STATUTORY PLANNING CONSULTATION RESPONSE

Application Number:	3/2026/0399
Proposal:	Approval of details reserved by conditions 7 (SW drainage), 8 (construction SW management) and 11 (landscaping scheme) of planning permission 3/2025/0852.
Location:	Samlesbury Aerodrome BAE Systems Operations Ltd Myerscough Smithy Road Balderstone BB2 7LF

Lead Local Flood Authority Position

**TYPICAL SECTION THROUGH ATTENUATION TANK**  
SCALE 1:20

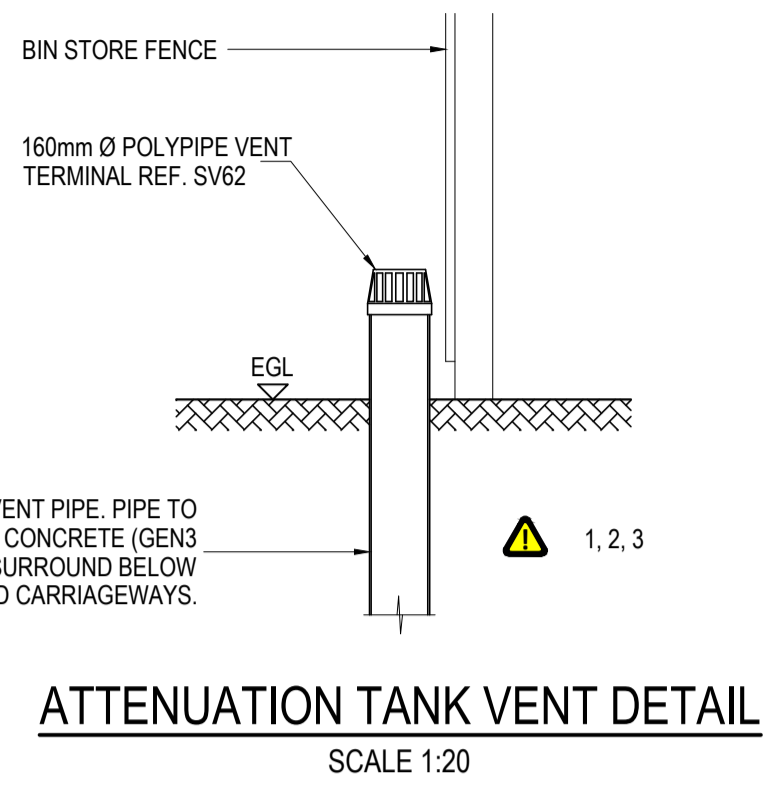
- The applicant has failed to provide evidence of a 40% climate change allowance applied to the 1in30 year event, as stipulated in the wording of the condition.
- The applicant has failed to provide appropriate evidence to support the proposal that approximately 20m³ of surface water to account for measures to manage the first 5mm of rainfall can be incorporated within the proposed attenuation tank.

The applicant has stated that infiltration is unfeasible on this development (an infiltration rate has not been calculated) but has proposed to design the attenuation tank to be an unlined system, therefore indicating that the first 5mm of rainfall can be managed through infiltration, using the base of the proposed attenuation tank / soakaway to achieve this.

Should the applicant be unable to provide evidence of appropriate infiltration capacity, then the applicant is expected to update the drainage calculations with an appropriate assessment of the attenuation tanks dimensions, thereby excluding the depth between the base of tank (71.550 AOD) and the outlet level (71.650 AOD), which would account for the proposed first 5mm of rainfall volume capacity (tank dimensions 15m x 14m x 0.70m).
